RE: *Revised Grading and Drainage Plan for Rios Auto Sales, Lots 1, 2 & 3 Nursery Addition, (L13/D9) (PWD-98-176) Engineer's Stamp Dated 2/24/98.*

**RE: Grading and Drainage Plan for Rios Auto Sales, Lots 1, 2 & 3 Nursery Addition,
(L13/D9) (PWD-98-176) Engineer's Stamp Dated 9/8/98.**

A PROPOSED PAVING PLAN  
FOR  
RIOS AUTO SALES  
(1251 BRIDGE BLVD. S.W.)  
BERNALILLO COUNTY, NEW MEXICO  
SEPTEMBER, 1998

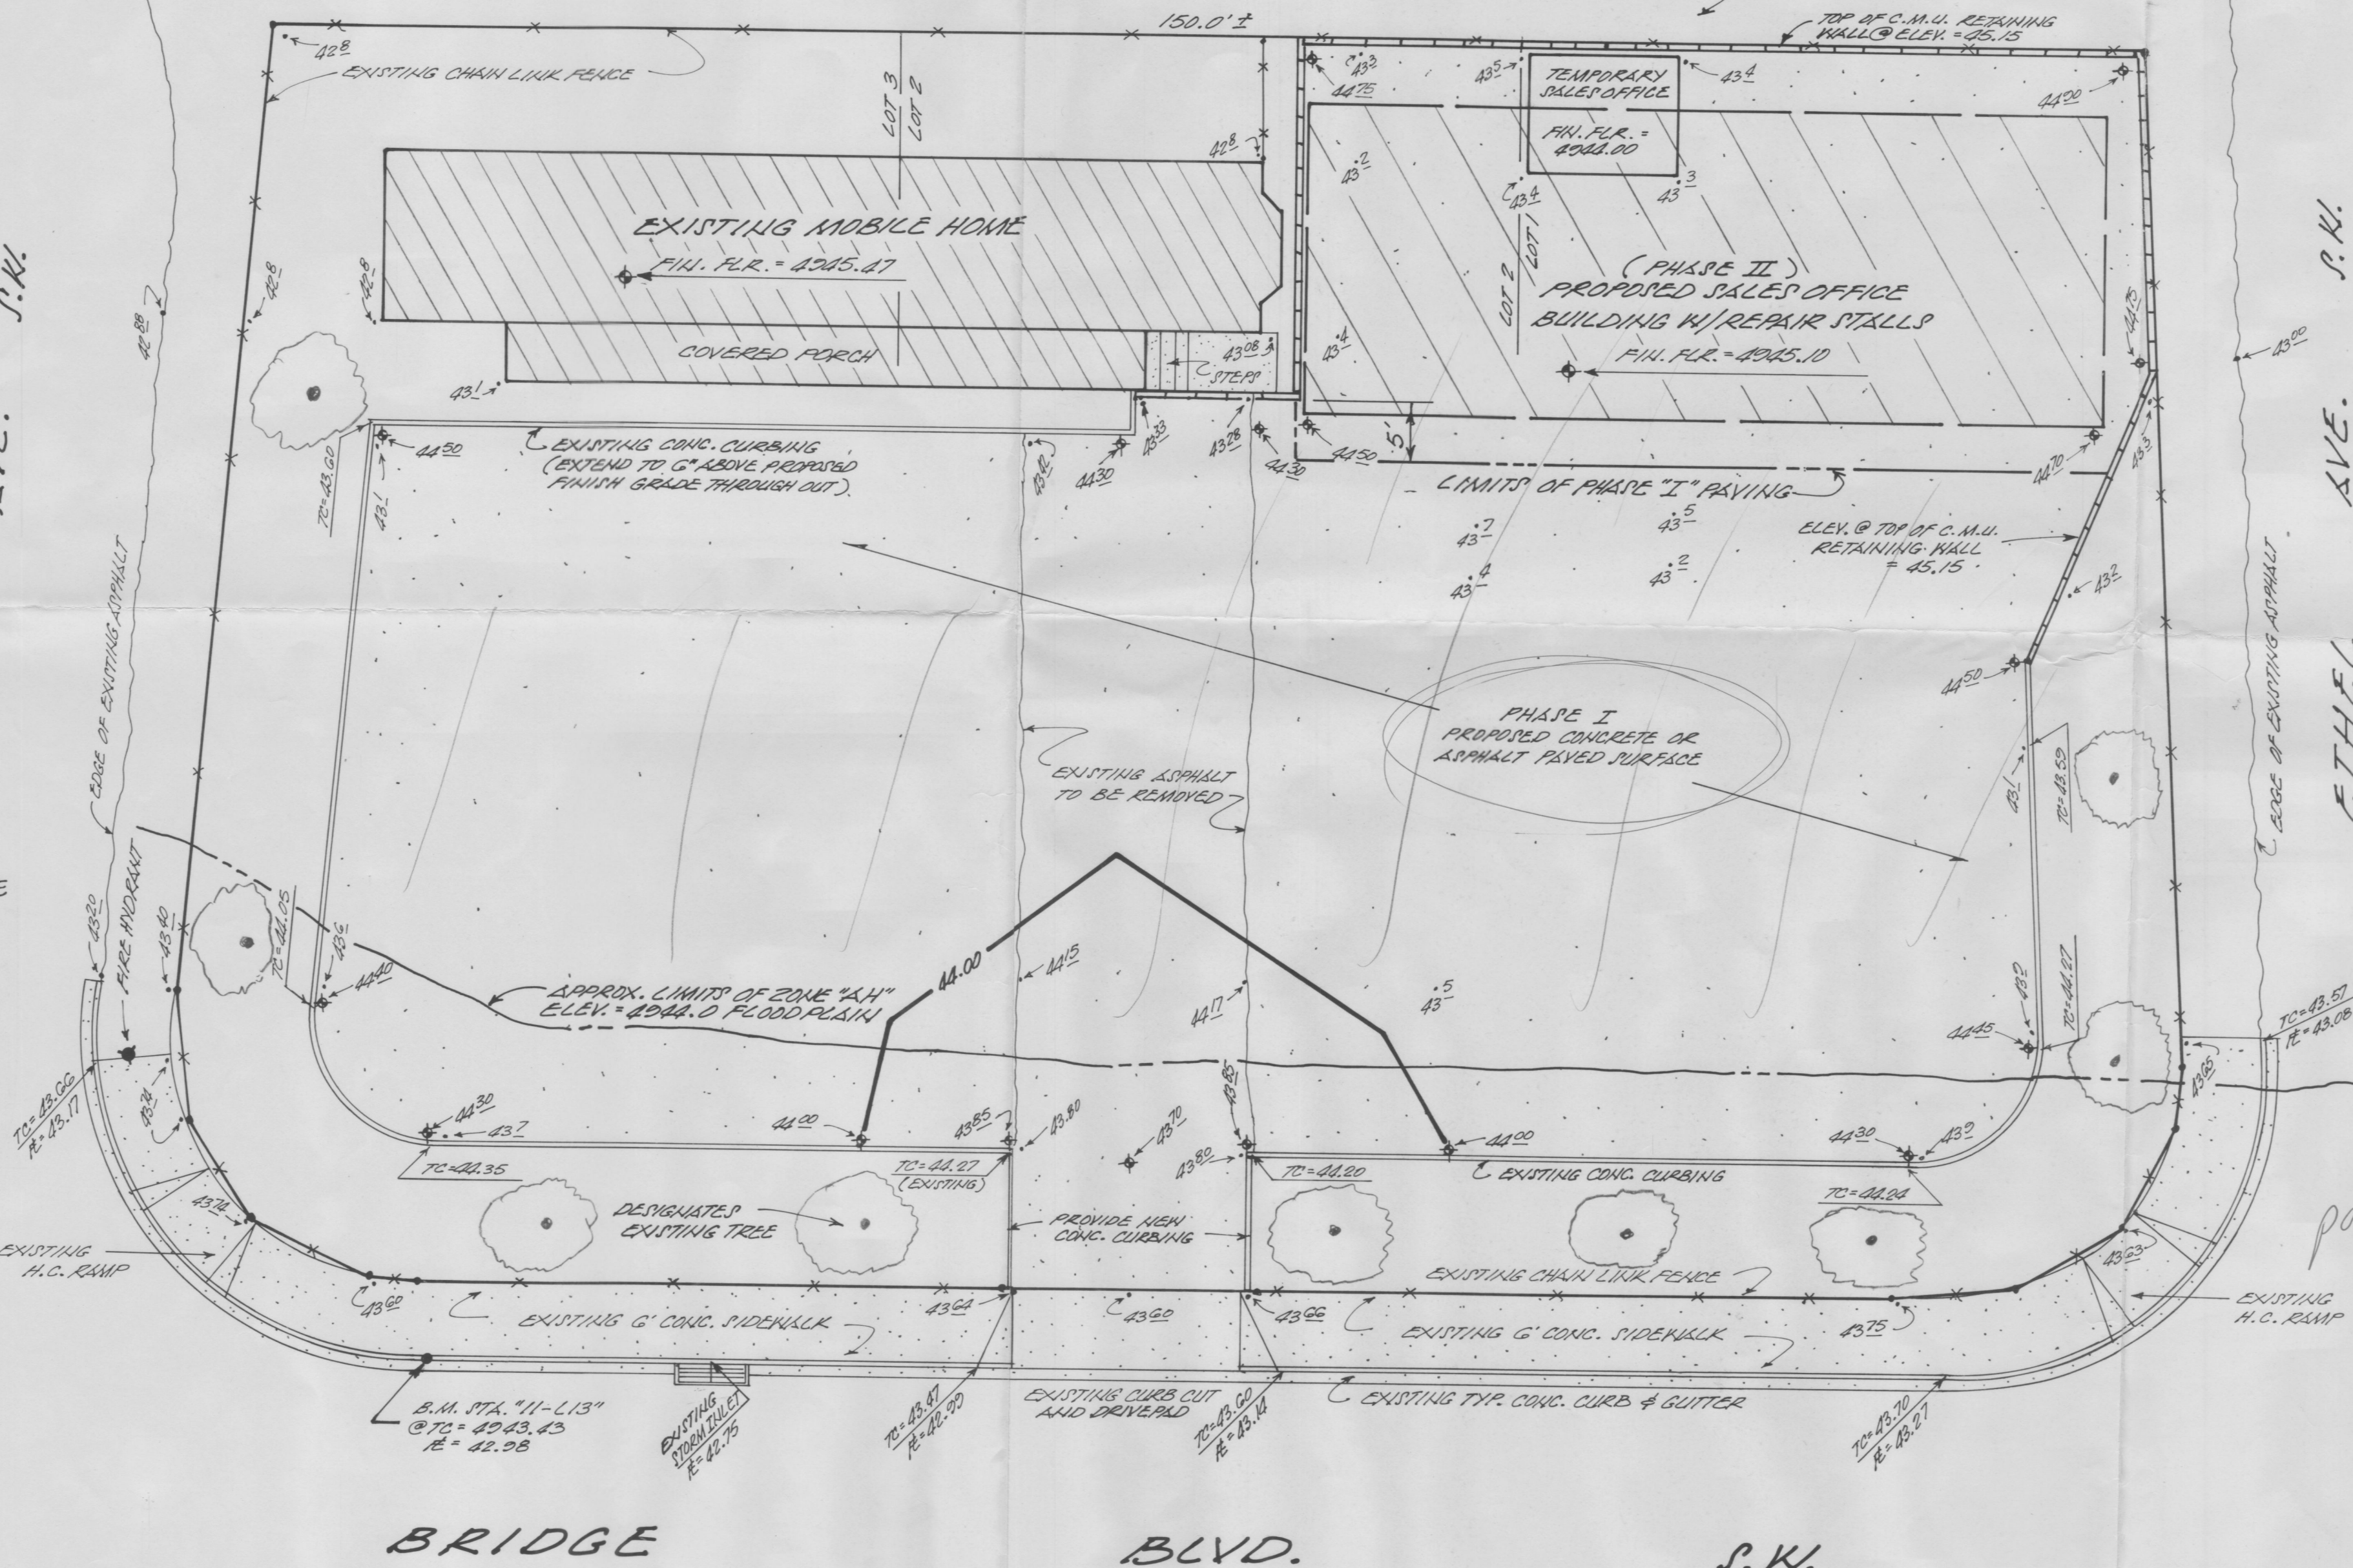
This plan proposes free discharge into the existing storm drain system in Bridge, however the plan does not address downstream capacity. Please provide documentation that the existing storm drain in Bridge has the capacity for the additional flows from this site.

REVISION OF  
 A PROPOSED PAVING PLAN  
 FOR  
 RIOS AUTO SALES  
 (1251 BRIDGE BLVD. S.W.)  
 BERNALILLO COUNTY, NEW MEXICO  
 SEPTEMBER, 1998  
 (REVISED: FEBRUARY, 1999)

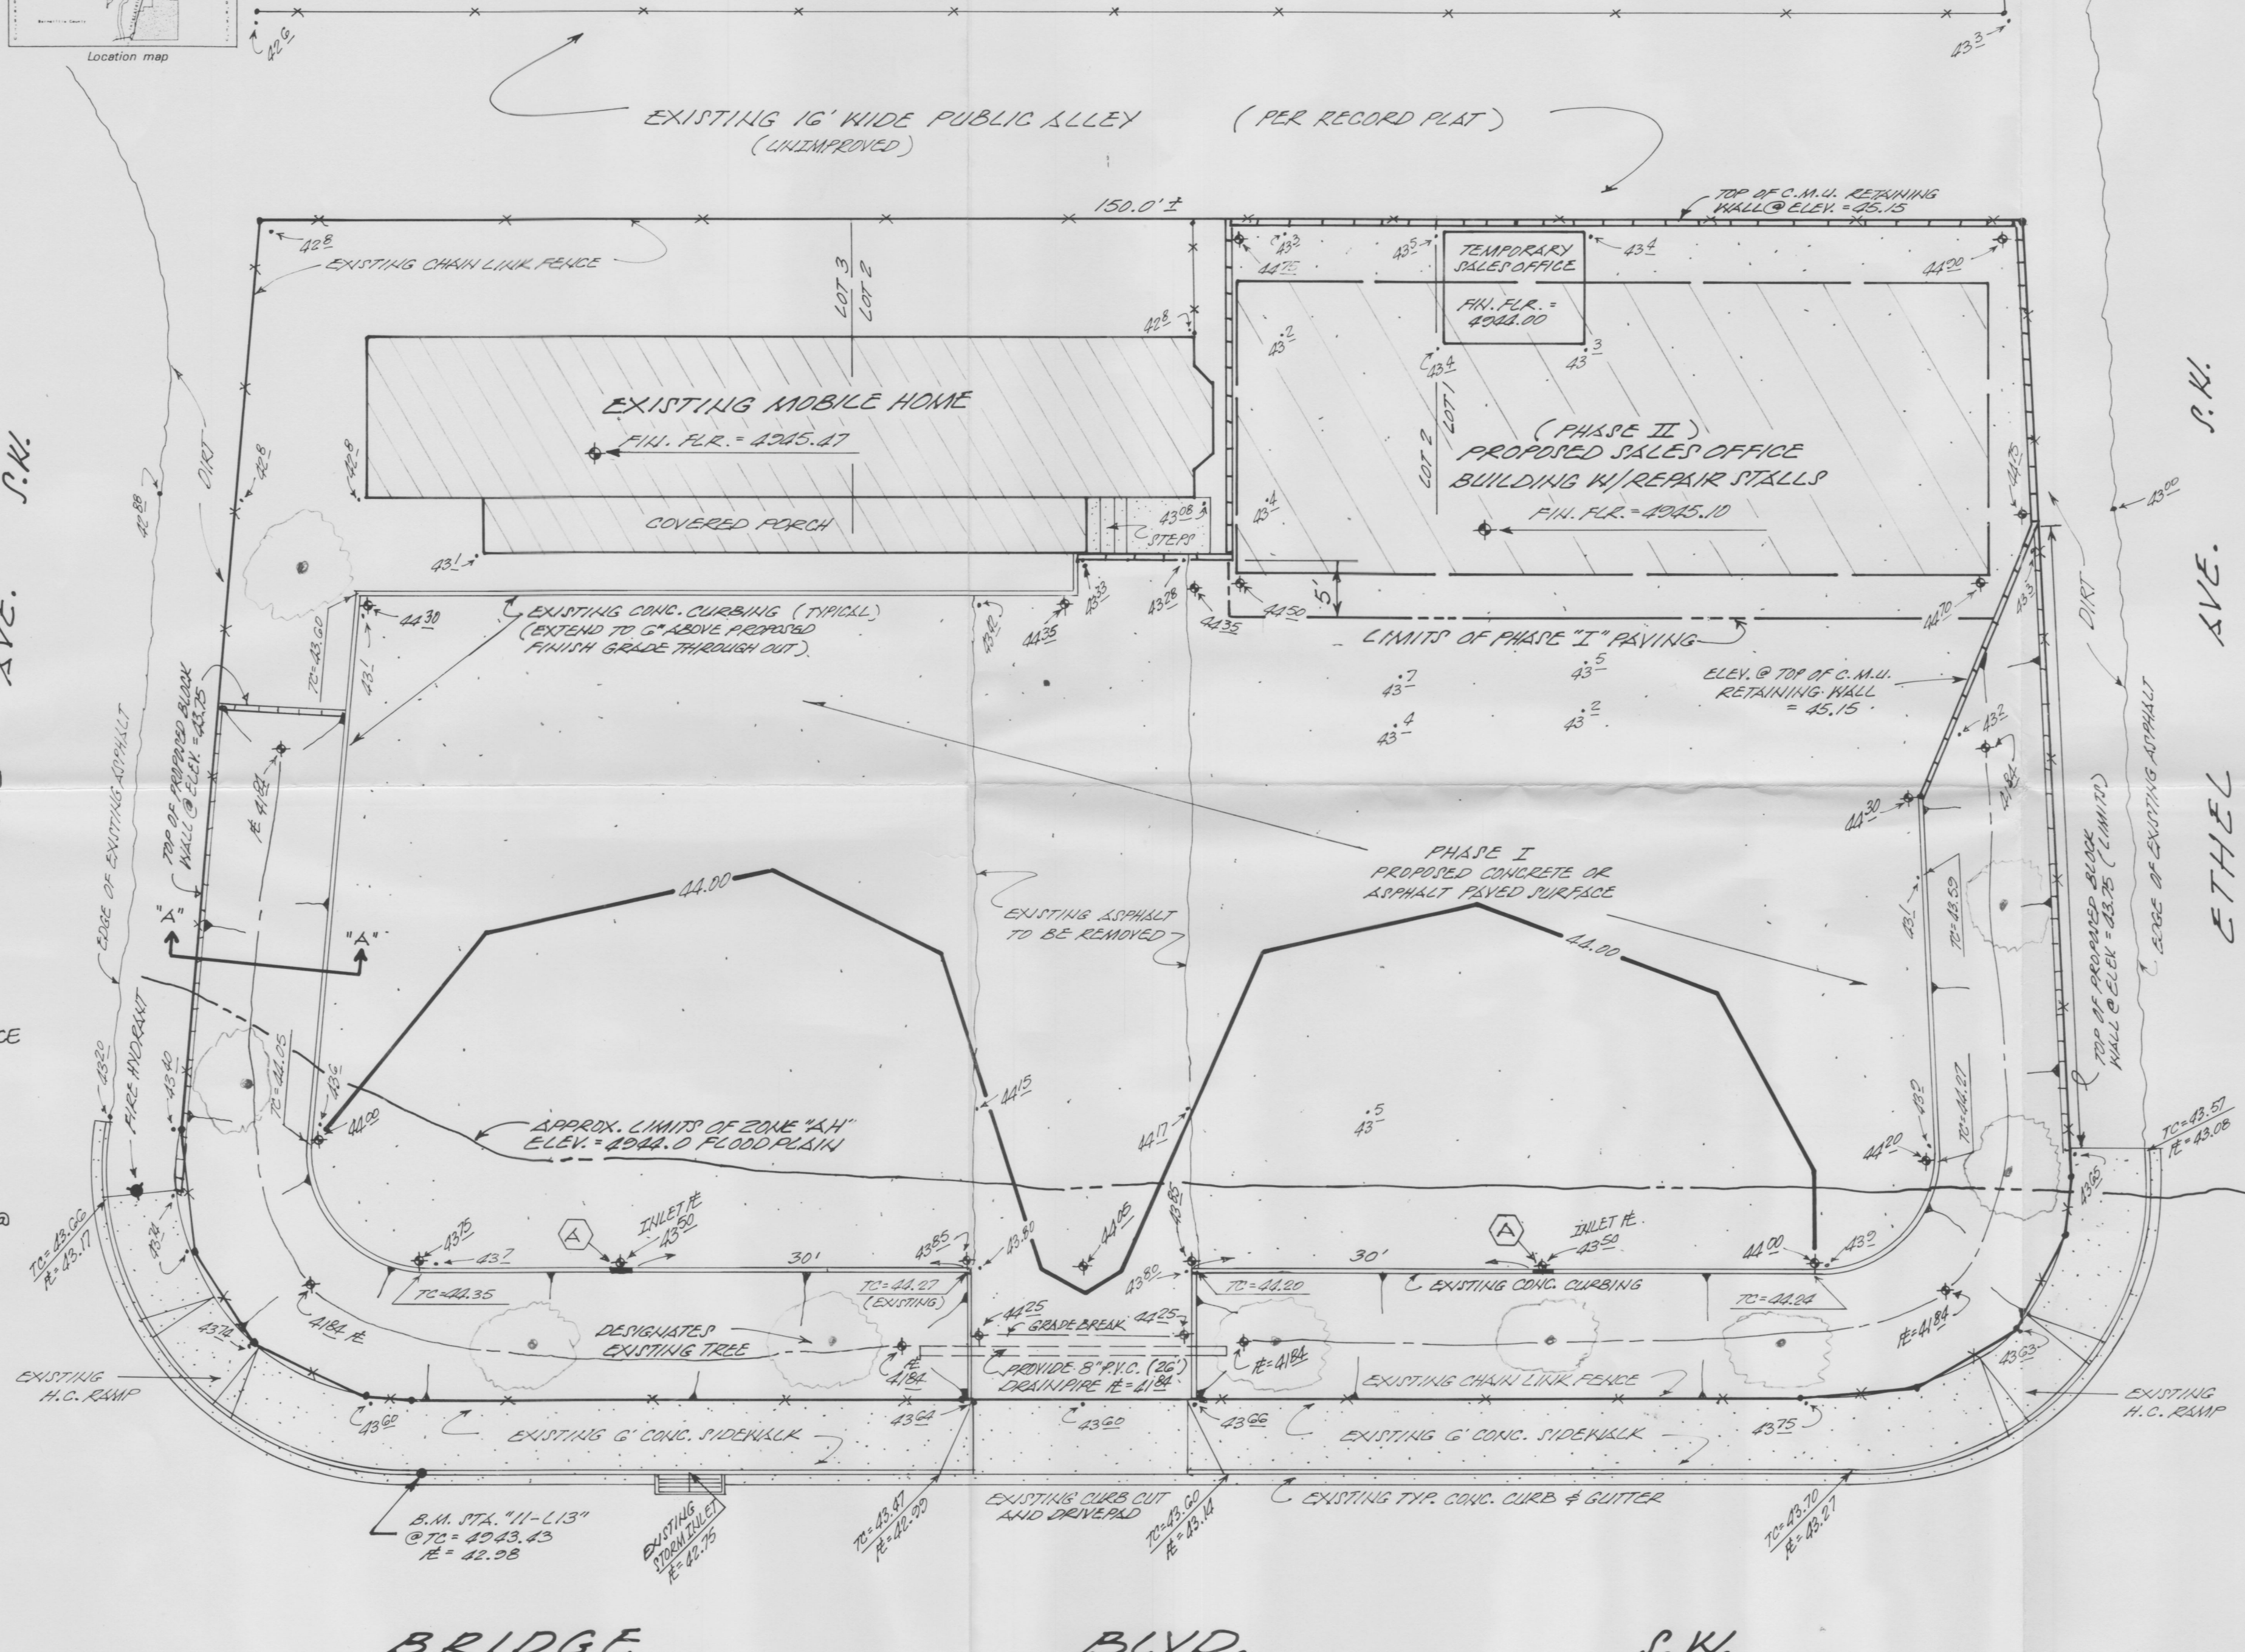
Based on the information provided, the above referenced plan is approved for Building Permit and Grading Permit release for Phase I only. Please note that prior to approval for Phase II, the plan must be revised to show the compensatory ponding required for the additional building.

They calculate the 100-year proposed volume to be 2218 cu.ft. but they only provide ponding for 1700 cu.ft.

They say that the volume to pond is 1659 cu.ft., so the 1700 is adequate. Why is only 1659 cu.ft. getting to the pond?

Also, whenever they develop Phase 2, they will have to provide compensatory volume for the building taking up space in the floodplain, so will they have enough room for more ponding on the site?
